Description: Erection of detached double garage

Location: 67 Peterborough Road
Crowland

Amendment: Existing trees to remain, shrubs added, Design and
Access attached (dwg. no. 11.011B)

ACKNOWLEDGEMENT OF AMENDMENT

BLOCK PLAN 1:500

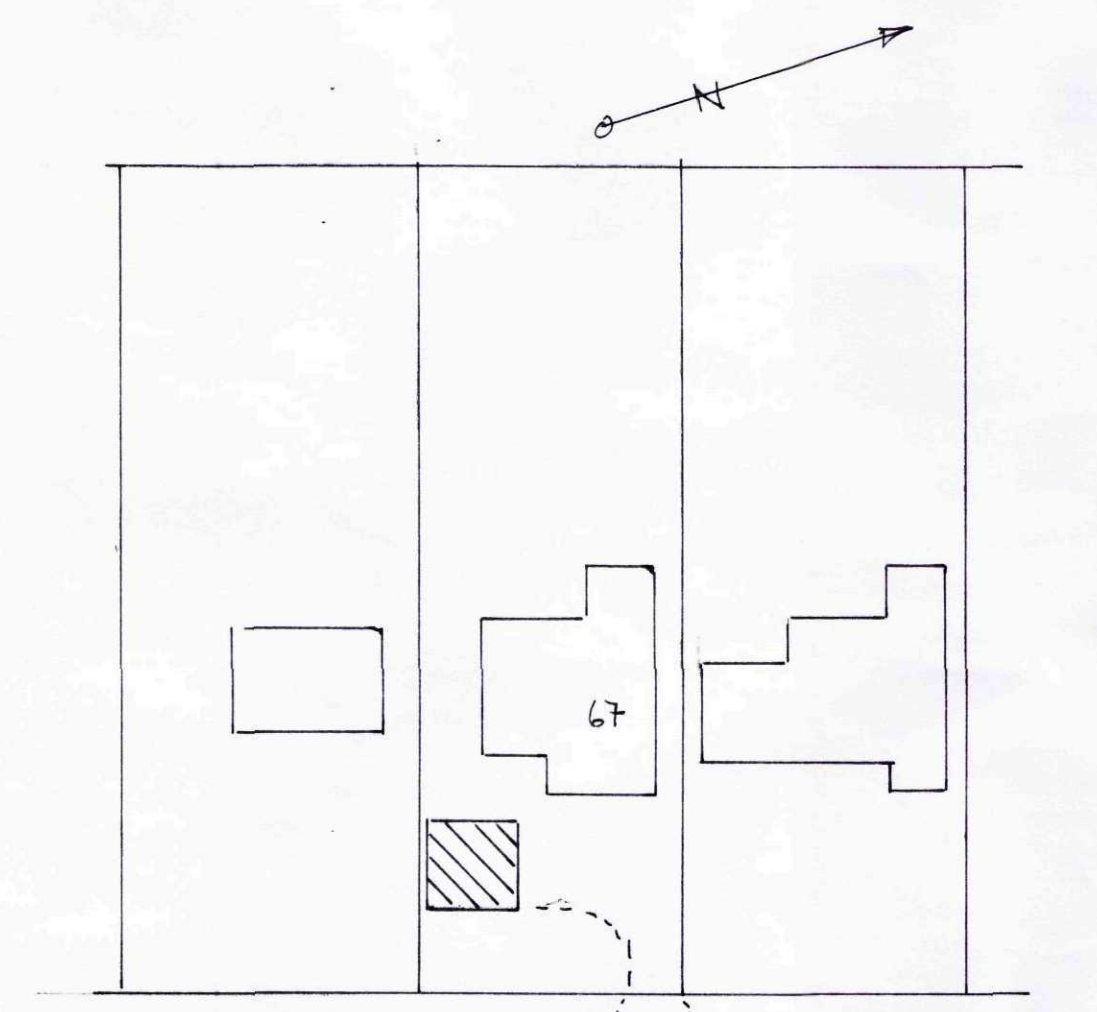
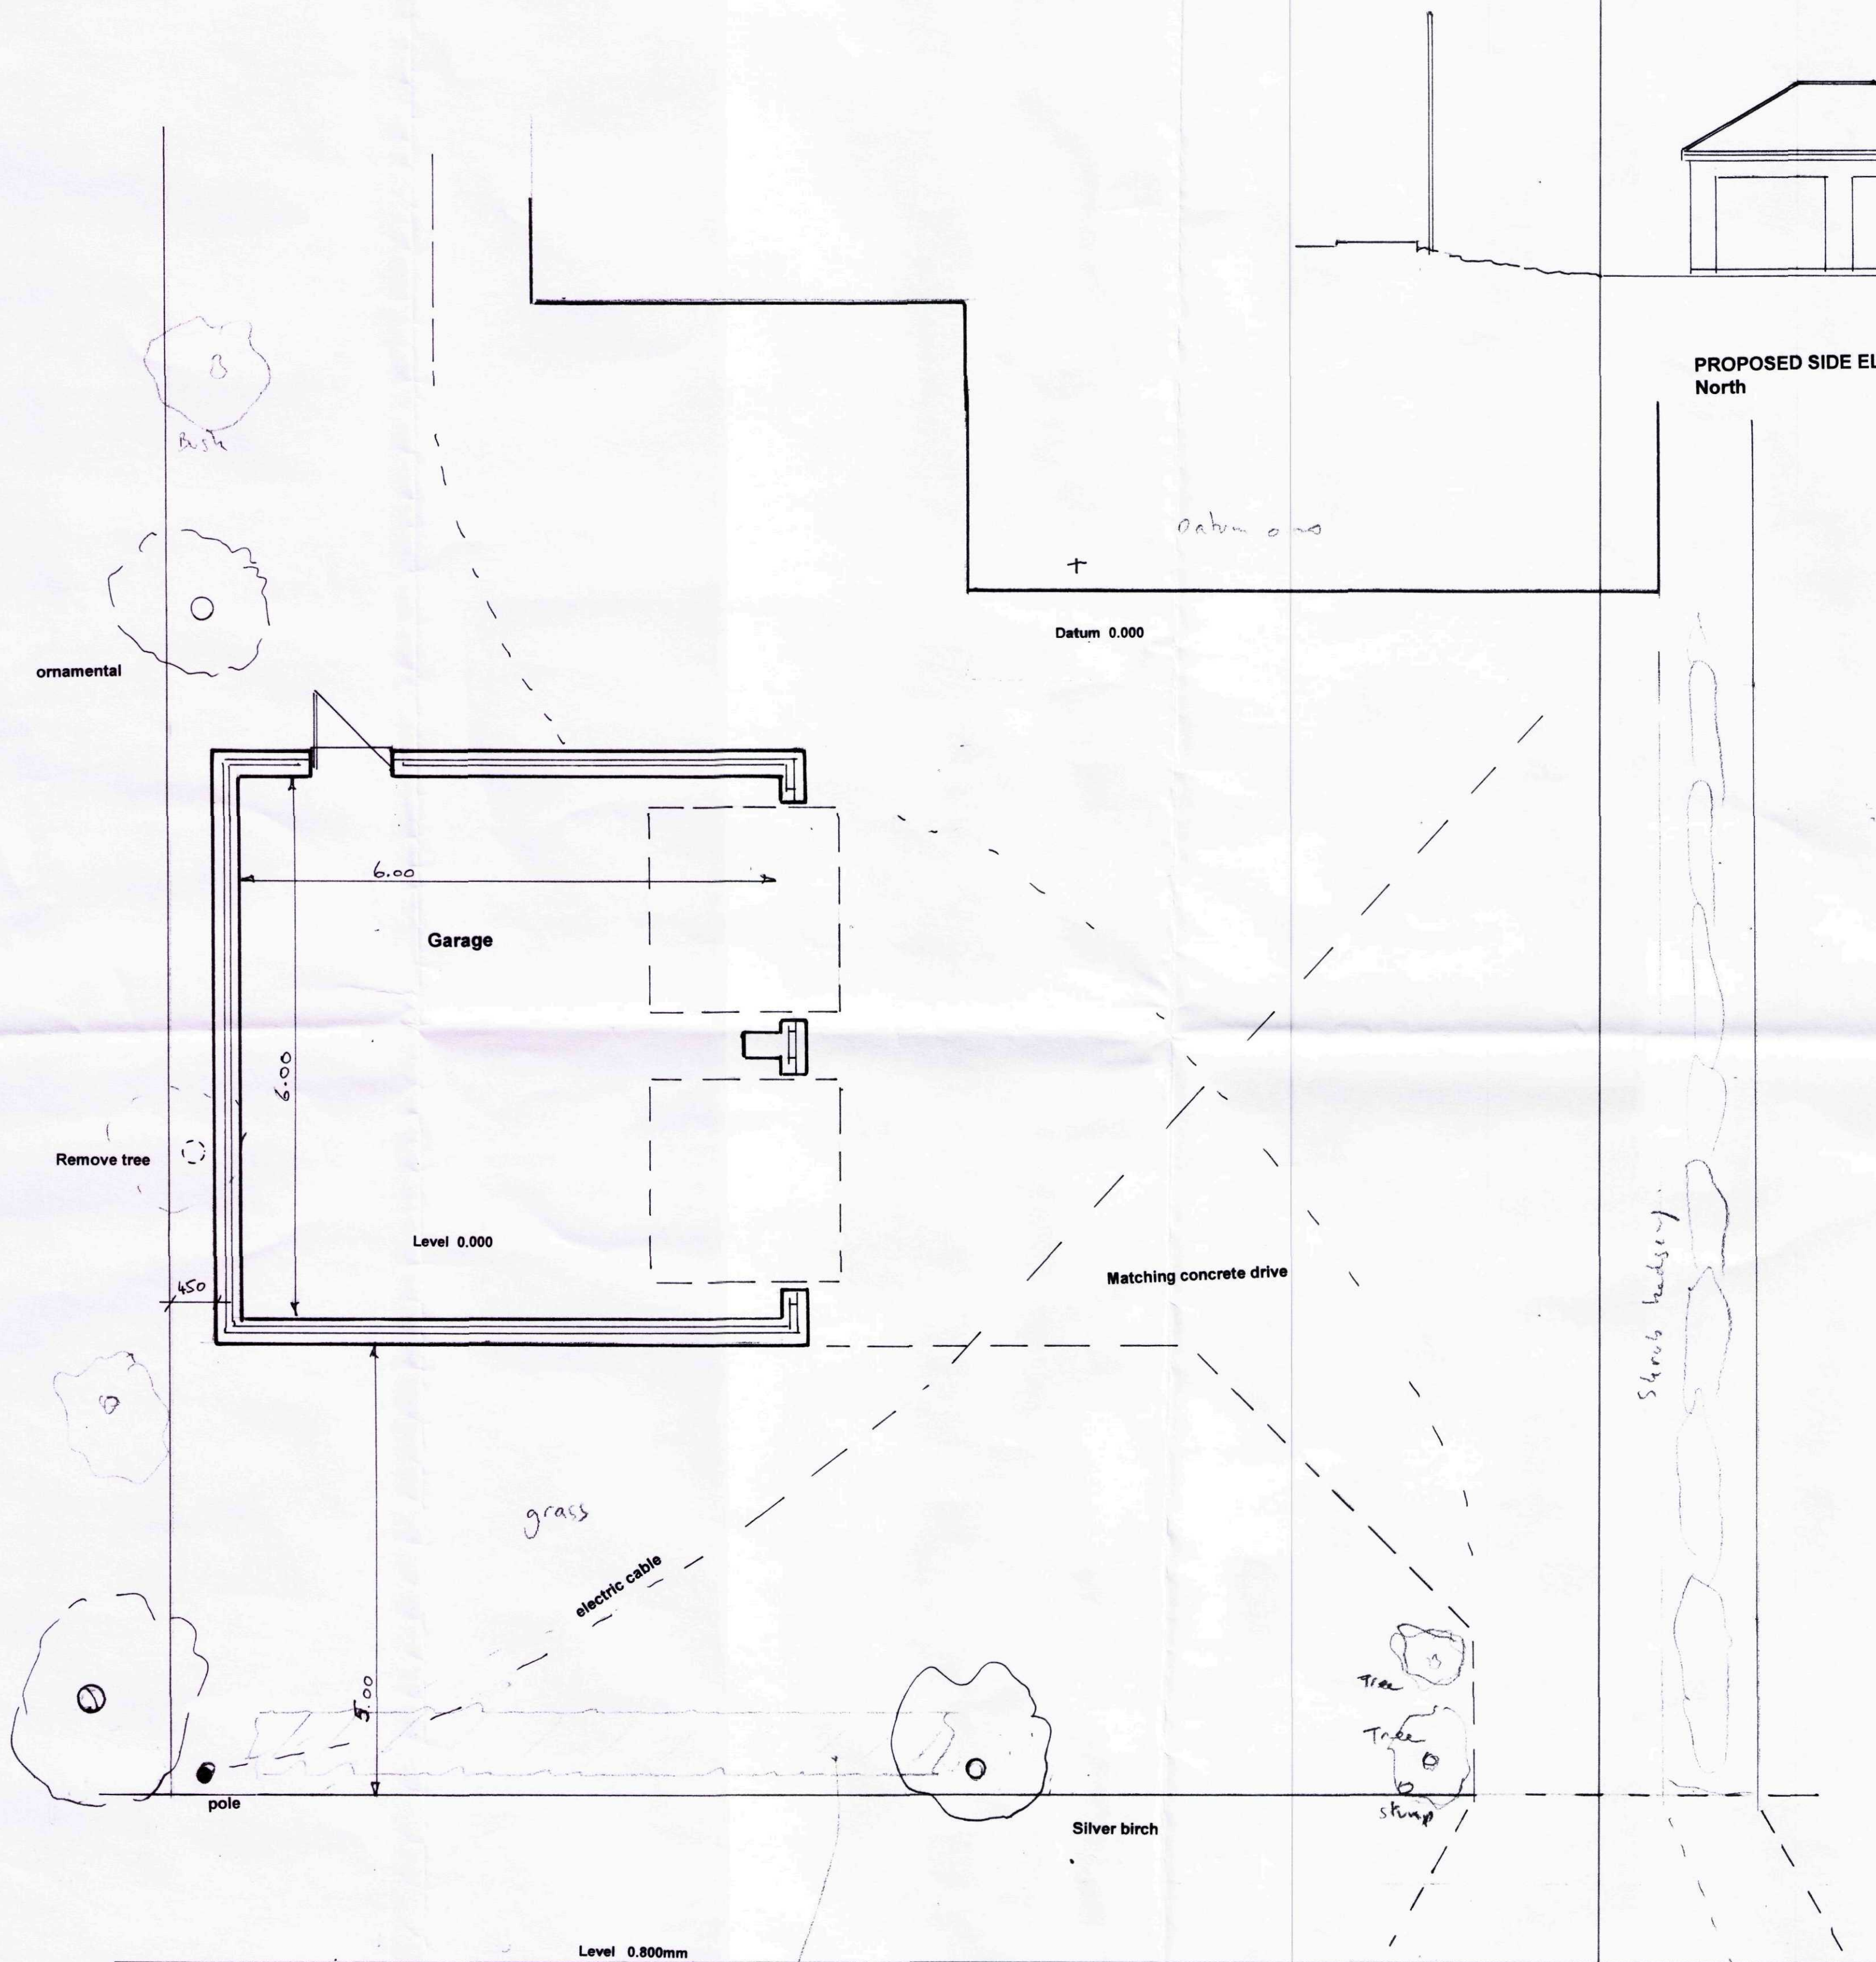
Remaining trees and shrubs added.

Please note that only one tree is to be removed. (Laural ?).
